TECHNICAL NOTE

2024s0643
Ledgard Mill
Helen Davies
27nd June 2024
Olivier Saillofest BEng MSc CEng
MCIWEM C.WEM
John Panesar BEng (Hons) CEng
MICE
Building on void - Technical parameters

JBA was commissioned by Helen Davies to address concerns raised by the Environment Agency regarding the design of a proposed building on stilts / on a void at Ledgard Mill, Mirfield (planning application ref: 2023/93539).

Lower Level 1: 50

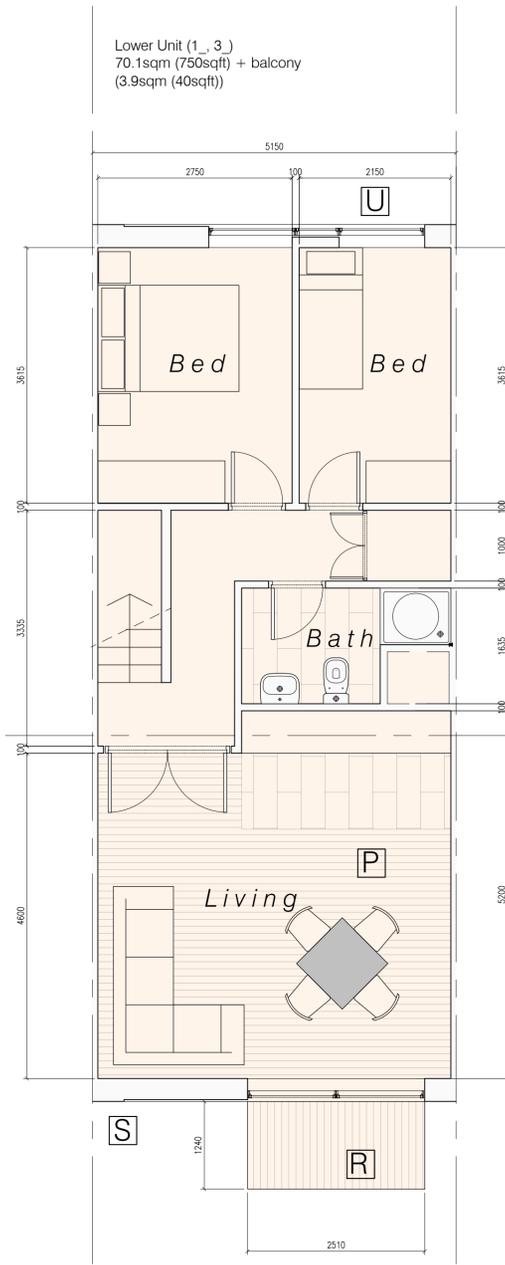
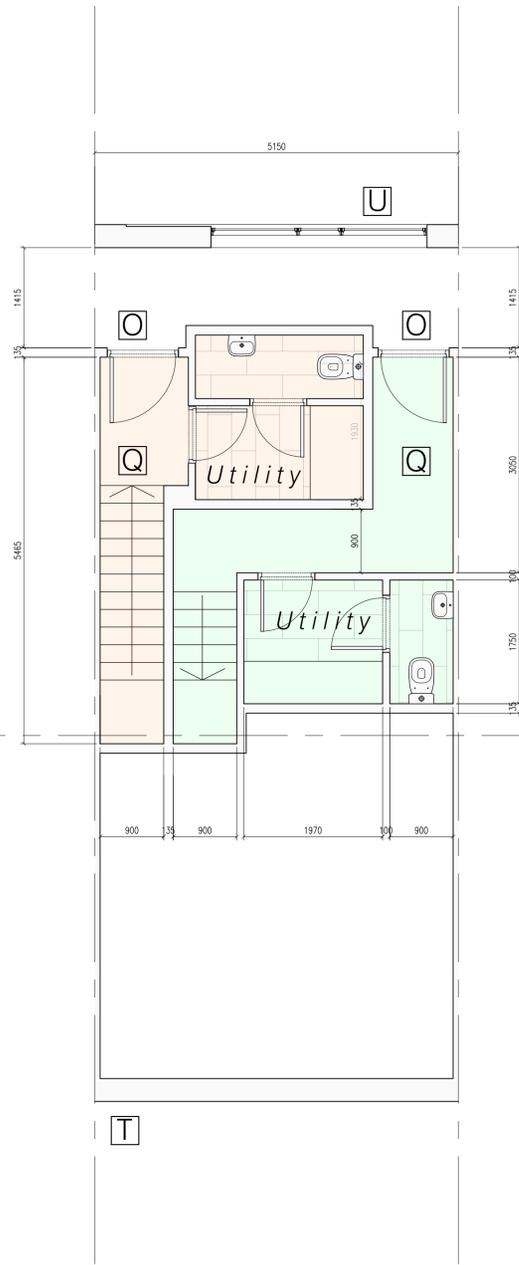
- 1 Confirmation of the single design flood level (1%AEP + appropriate climate change allowance), including the source of this data.
- 2 Clear detailed drawings of the proposed void solution including the dimensions of the openings.

It is recommended that Architectural drawings submitted on the panning portal are updated to reflect the above design parameters.

- Void base level: at existing ground level (c. 44.55m AOD)
- Void opening width: 4.26m for every 5.15m length of wall
- Pier (between void inlets) width: 0.89m
- Minimum void soffit level: 45.68m AOD
- Open void length per length of wall: 4.26m for every 5.15m length of wall, on the sides of the proposed building facing incoming overland flows (i.e. north-eastern and south-western sides)
- Opening through side walls (parallel to overland flows): No
- Solid to void ratio within void (due to vertical walls, supporting frame, beams, etc): 17%
- Vertical bars: yes, 10mm diameter with 100mm spacing
